SUBJECT: RESPONSE TO MODIFICATION OF BIRRIWA SOLAR FARM SSD-29508870-MOD-1

Thank you for the opportunity for Council to provide a response to the Modification request for Birriwa solar farm. Please find following comment from Mid-Western Regional Council in regard to this application for modification.

Figure 7 | Birriwa Bus Route South and site access point

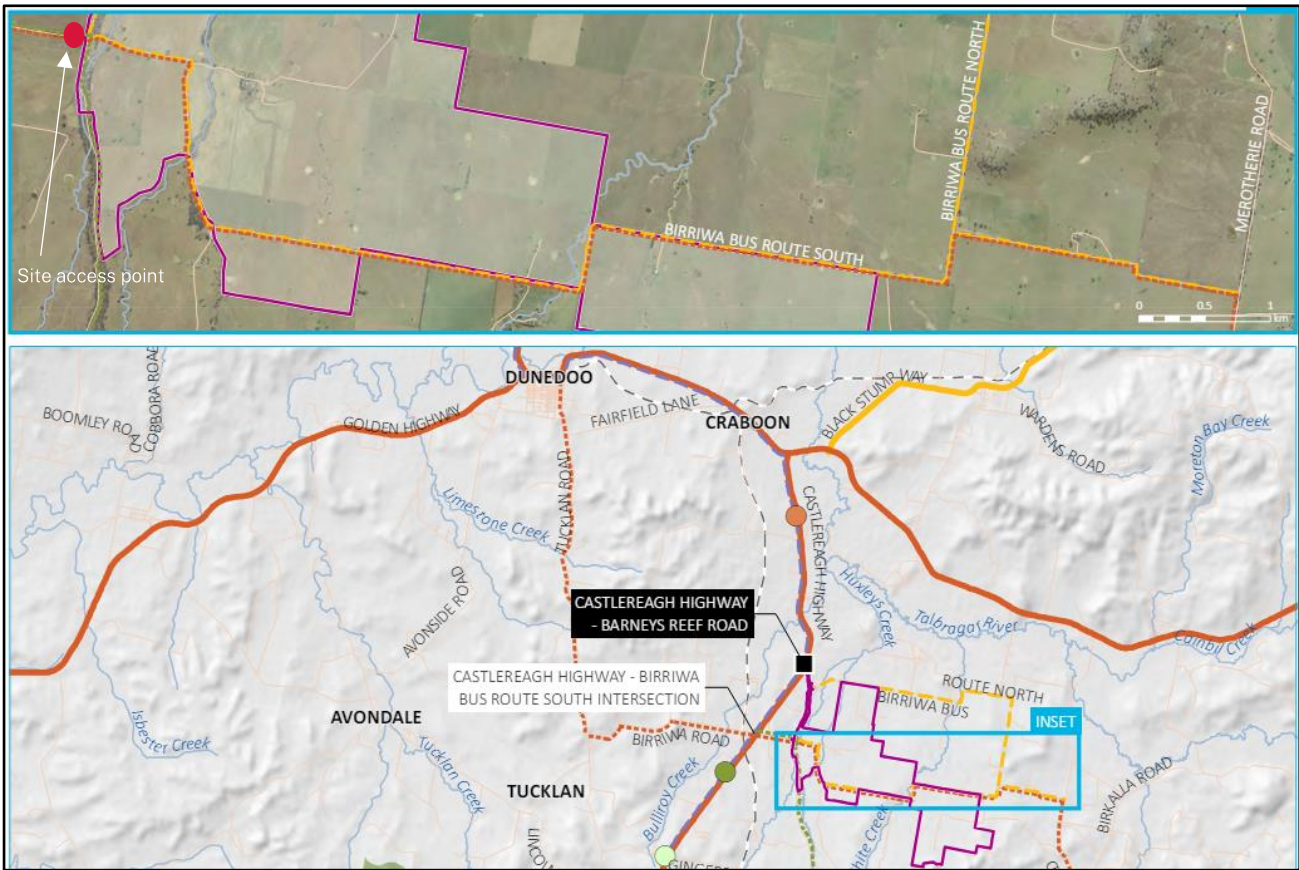
Council acknowledges the modification introduces a secondary access route along Merotherie Road and Birriwa Bus Route South to the site entry. Consultation with Council on this option has been ongoing and the alternative access is **generally supported**, subject to:

- Suitable road upgrades being delivered as described in the modification report.
- Acknowledgment that sections of Birriwa Bus Route South contain substandard curves that may require property acquisition to achieve compliance with Austroads Guidelines.

- Appendix 5 of the project consent must be amended to capture the additional road upgrades to Council's satisfaction.
- The section of Birriwa Bus Route South between Merotherie Road and the site entry should be constructed in accordance with Austroads Guidelines and Appendix 5 upgrade requirements, except where Council agrees to vary the design to preserve biodiversity while maintaining road safety standards.

"Resurfacing and widening of Birriwa Bus Route South to a minimum width of 9.2m, which includes 7.2m seal and 2m unsealed shoulders (2x3.1m travel lanes + 0.5m sealed shoulders

both sides + 1m unsealed shoulders both sides) except where agreement has been reached with the roads authority to vary this standard.”
